Review of the NorthConnex EIS

Written by Ian Longley and Peter Sturm on behalf of the Advisory Committee on Tunnel Air Quality

2nd December 2014

The following review is based on the document “NorthConnex Submissions and Preferred Infrastructure Report, Chapter 2” delivered on Nov 30th 2014.

Figure 2-13 24 hour NO₂ concentrations (ug/m³) - January to August 2014

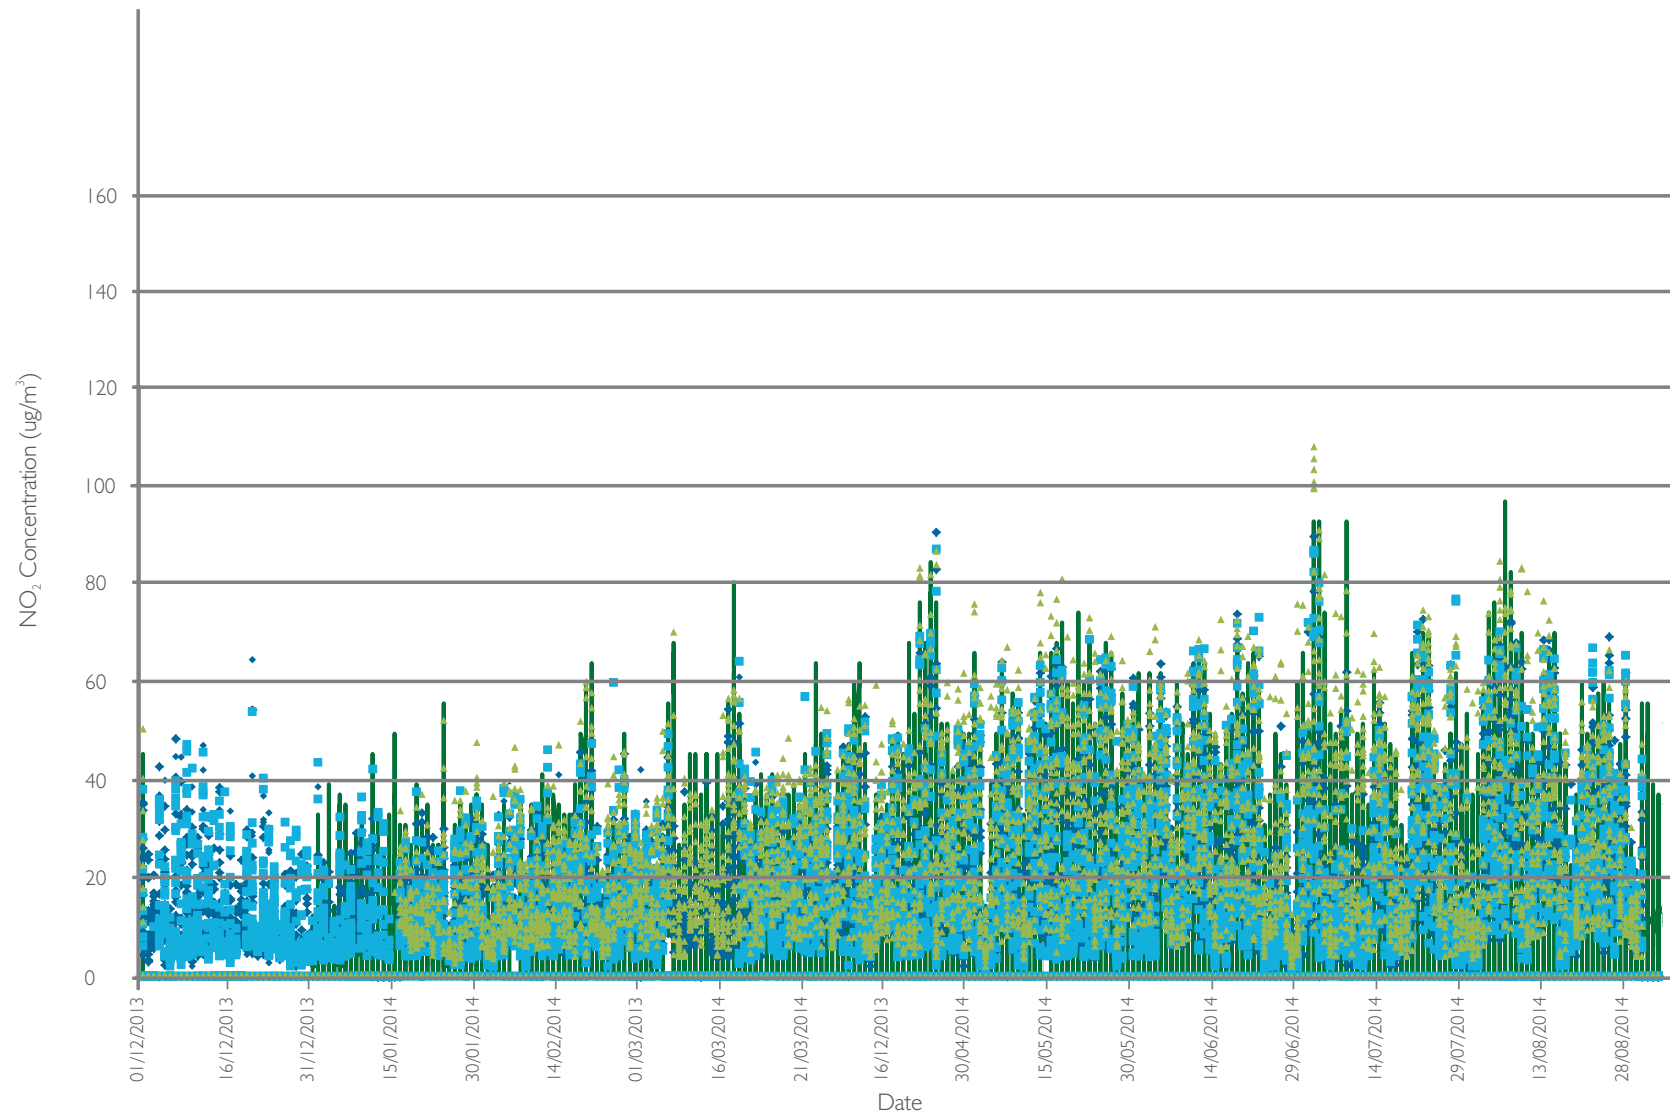
The format of figures 2-13 and 2-14 is unfortunate as it is hard to make any general conclusions. Given that these are contemporaneous data a correlations plot would facilitate much clearer comparison than times series. The statement “Overall, the maximum Prospect/ Lindfield data are considered to be representative of NO₂ levels in the project area, and slightly higher than data collected from monitoring stations along the project corridor in most cases” cannot be verified from the material provided. However, we agree that large deviations between OEH and project site data are not apparent and we find that the use of OEH data to represent background NO₂ levels at non-roadsite sites in the project area is appropriate. For PM₁₀ data figure 2-14 indicates that concentrations between OEH and project sites are of similar magnitude on average, but there are clearly periods when there is significant deviation. We find that the use of non-local data in this way

Figure 2-15 CAL3QHCR validation - Brickpit Park NO₂ (1 hour)

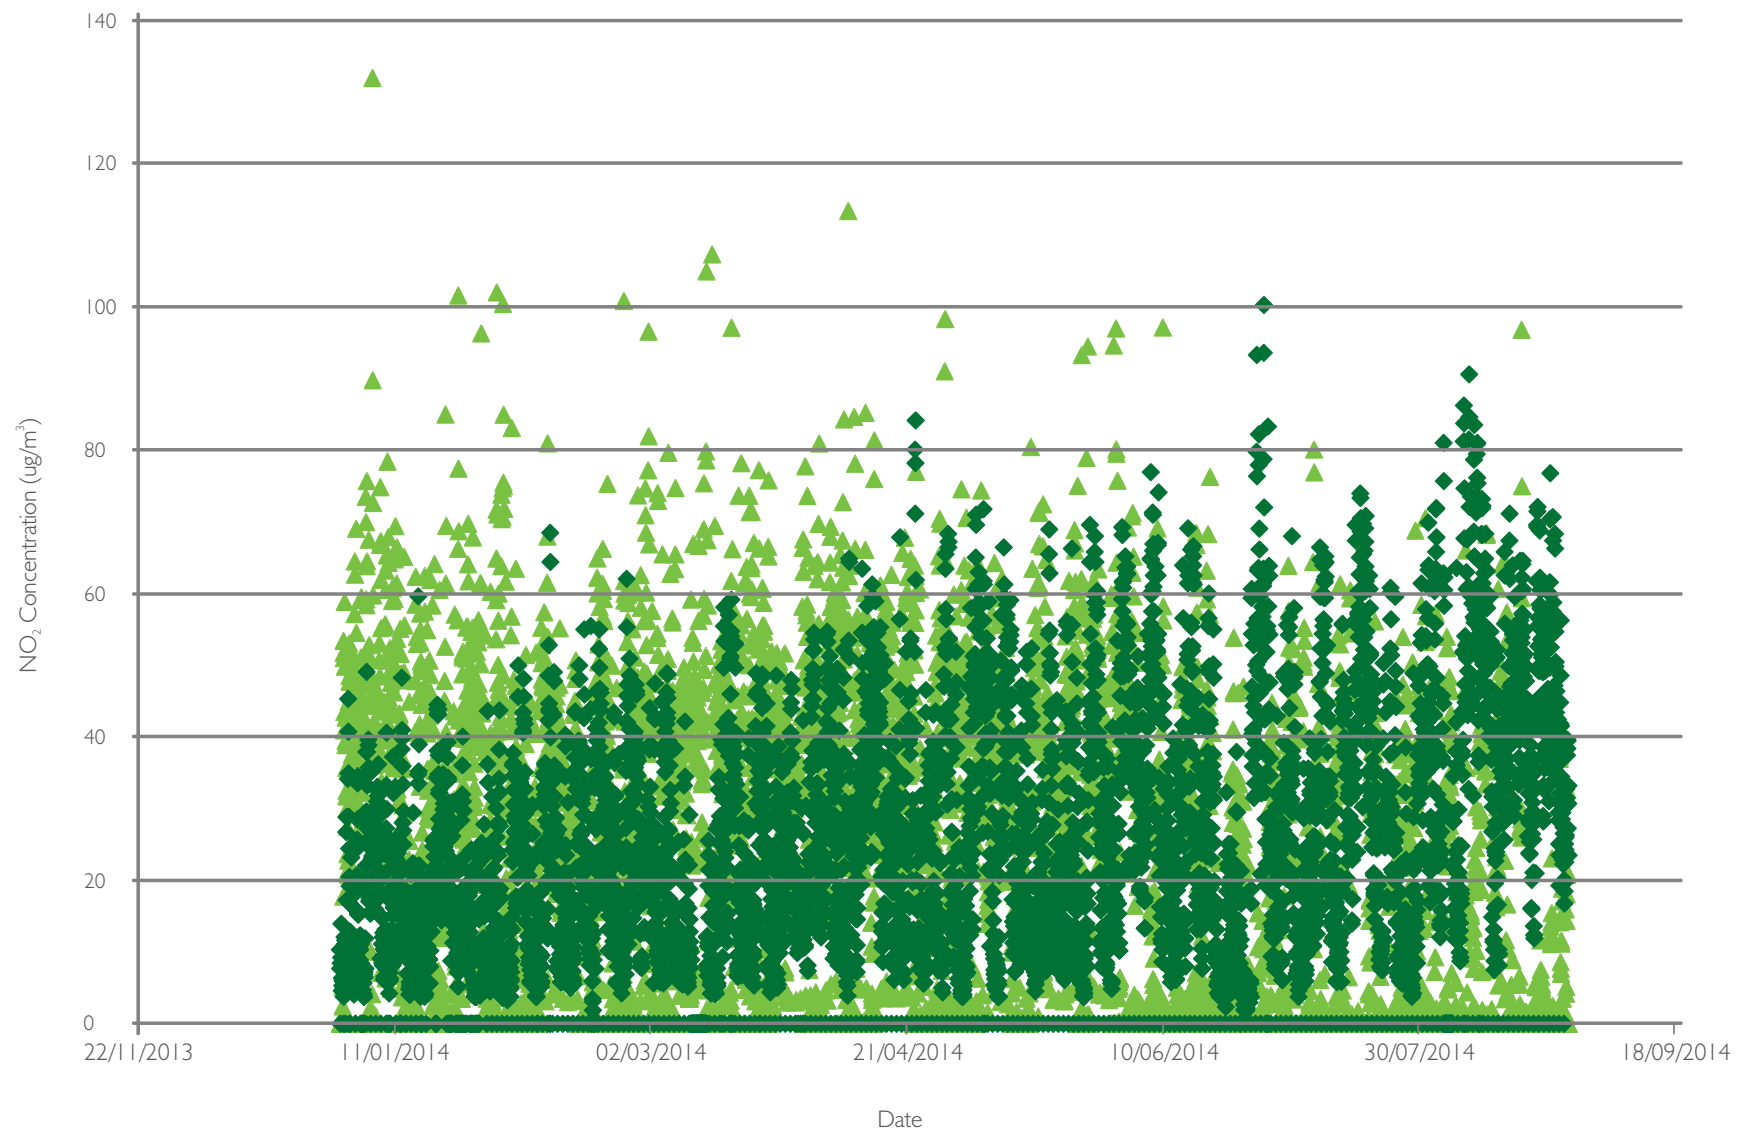
Figs. 2-15 or Fig. 2-16 contain very little information – it is not possible to tell from these whether the model is performing well or poorly, other than the range of values predicted and observed are similar. However, we agree with the statement "These comparisons results demonstrate that the surface road modelling predictions do not account for 100 per cent of the background pollutant concentrations measured at the Brickpit Park and Observatory Park monitoring stations."

Figure 2-17 CAL3QHCR validation - Brickpit Park PM_{2.5} (24 hour)

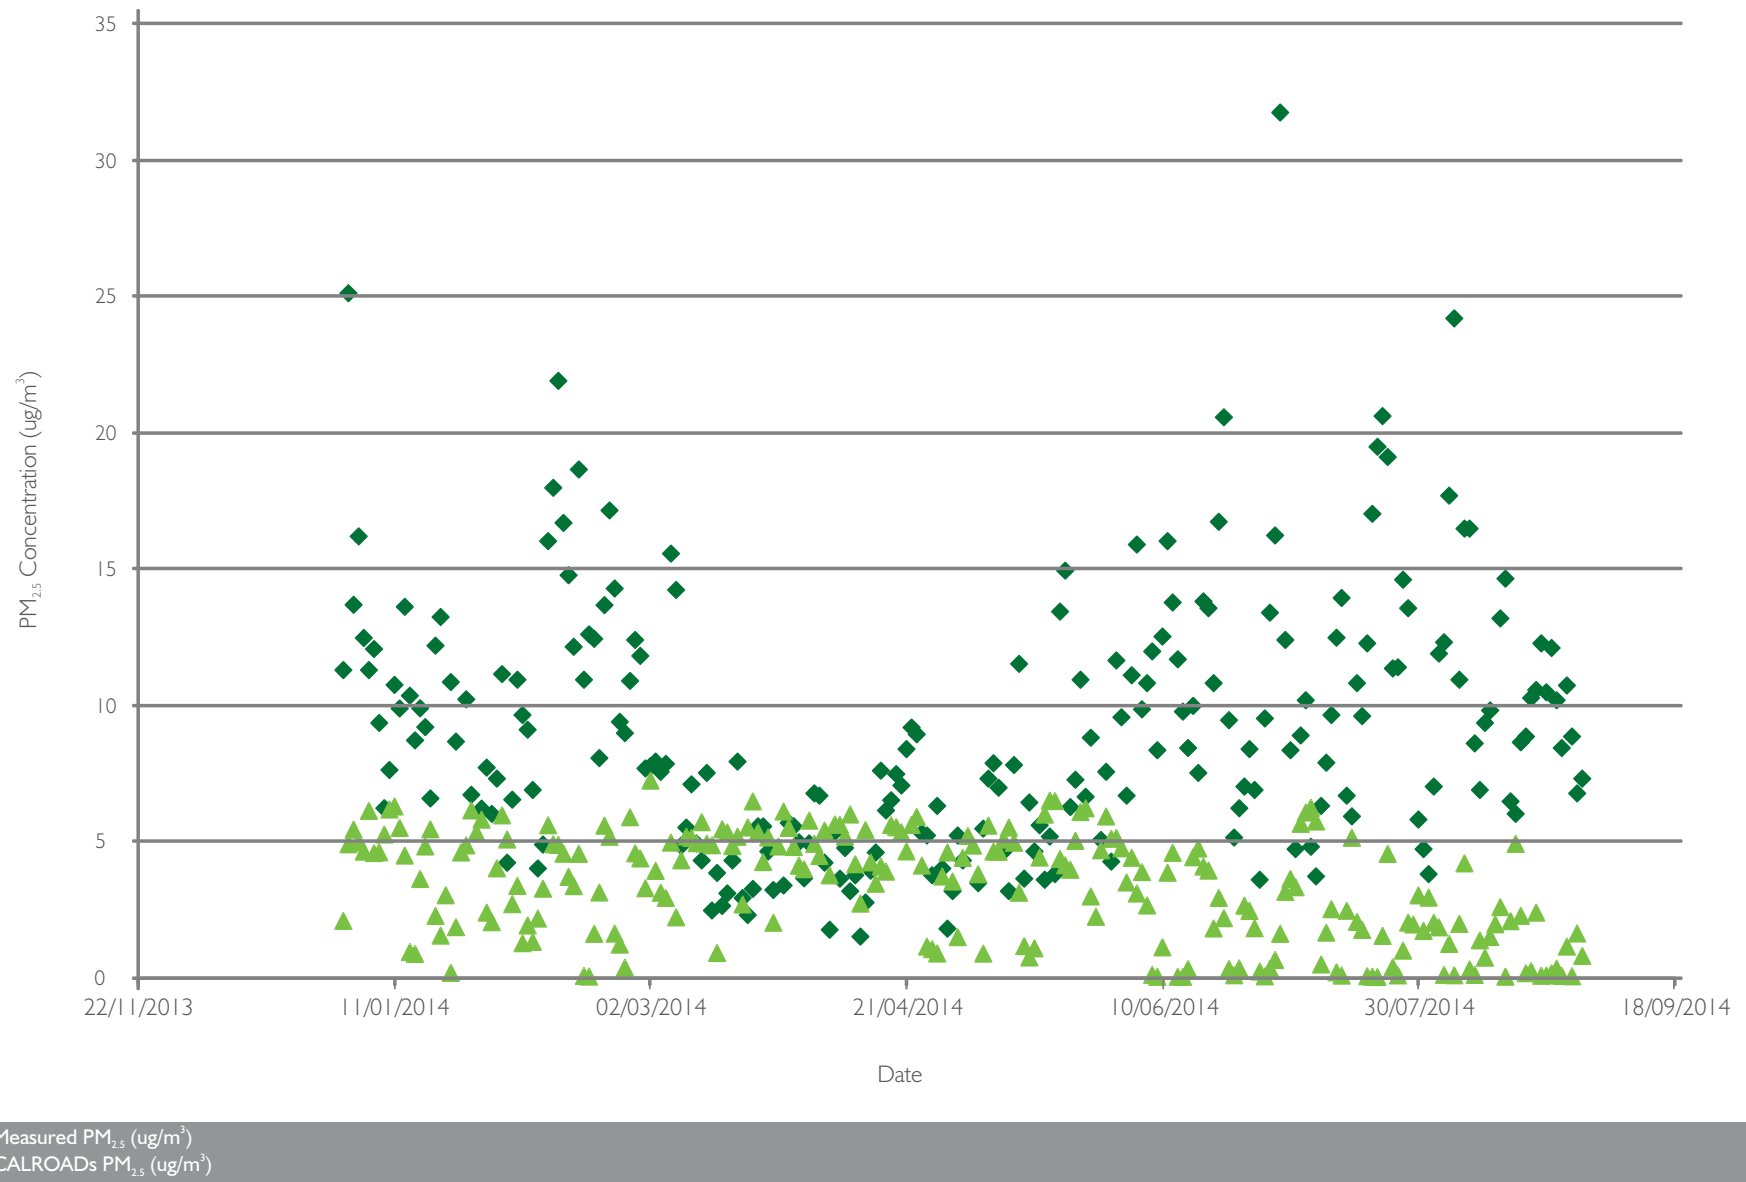
Figures 2-17 and 2-18 concern PM2.5. Here it is visible that there is in general at least a 2-fold difference between calculation and measurement, i.e. the calculation is giving 50% and less of the monitoring data (except during one period mid-March to mid-June at Brickpit Park).

Figure 2-19 Comparison of project methodology and alternative methodology

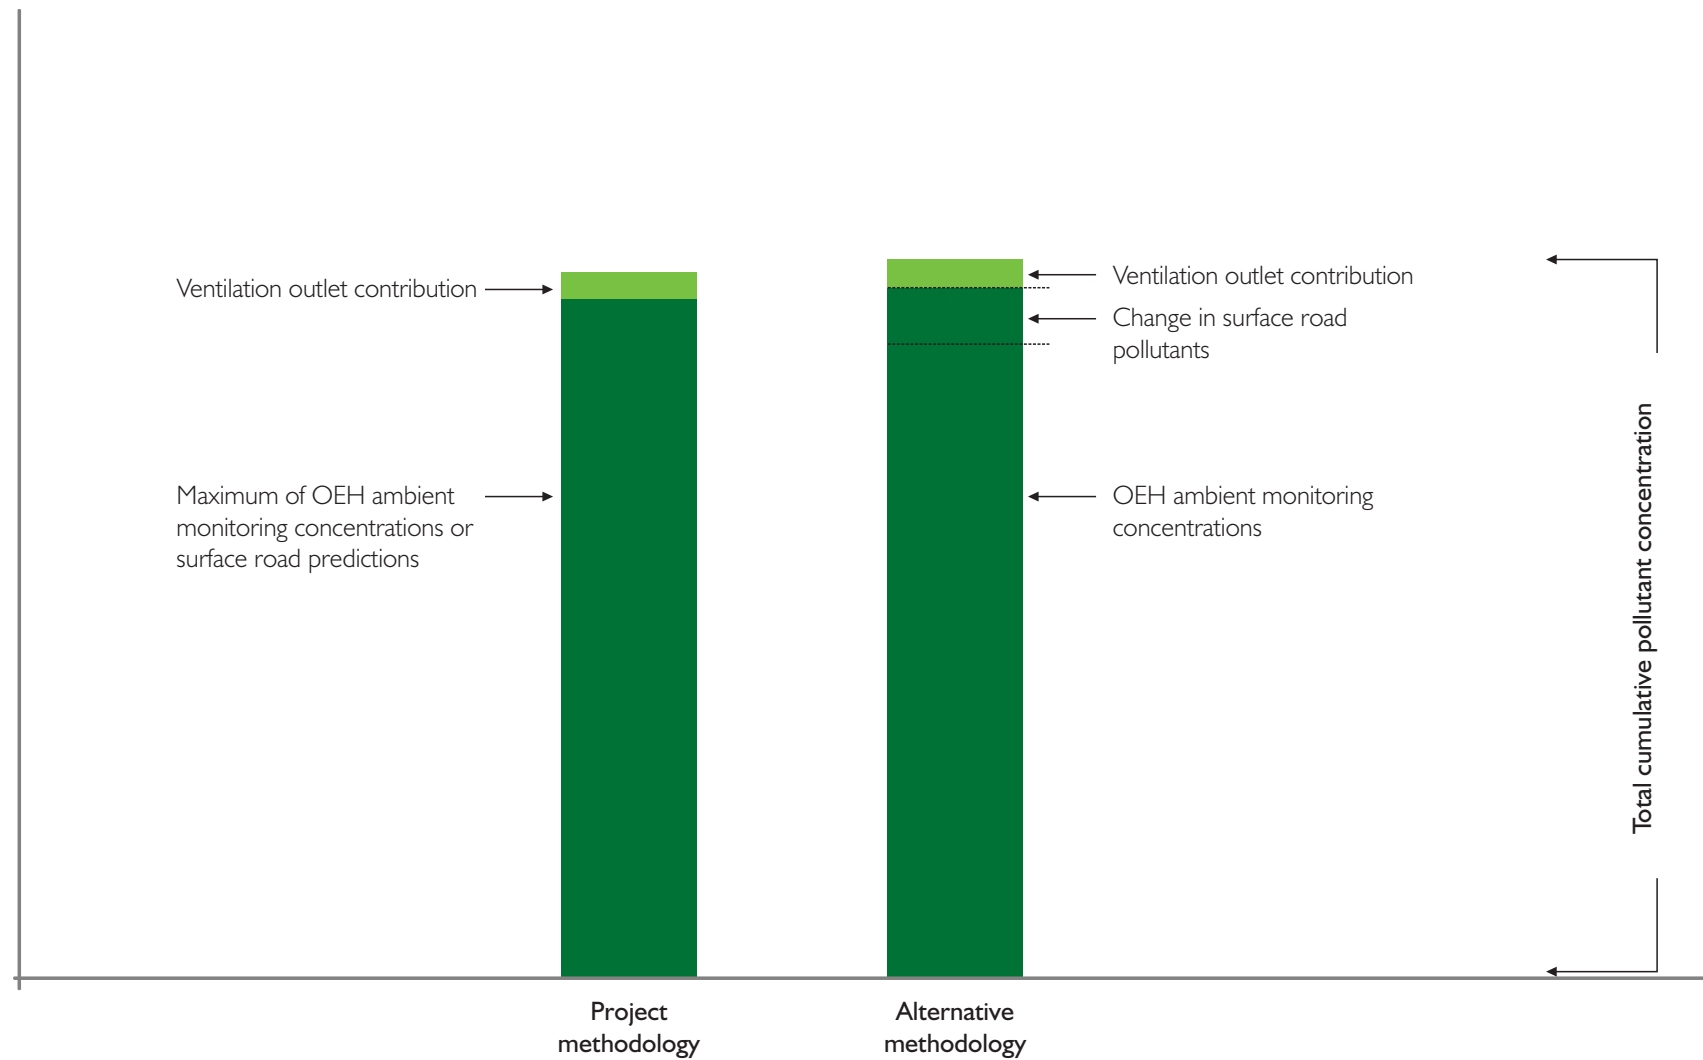
Page 248 and Figure 2-19 deal with an alternative approach. The alternative approach uses the OEH ambient monitoring data as background, the change in surface road pollutants as ‘surface road’ contribution and the ventilation outlet contribution to end up with the ‘total cumulative pollutants concentration’. Such an approach can only be taken when the ‘background’ is the real ‘status quo’ description of the air quality at that receptor point. The OEH station values do not describe the ‘real status quo situation’ in the project area. Hence it must fail in describing properly any project related cumulative situation. Hence any further discussion about this method is not productive.
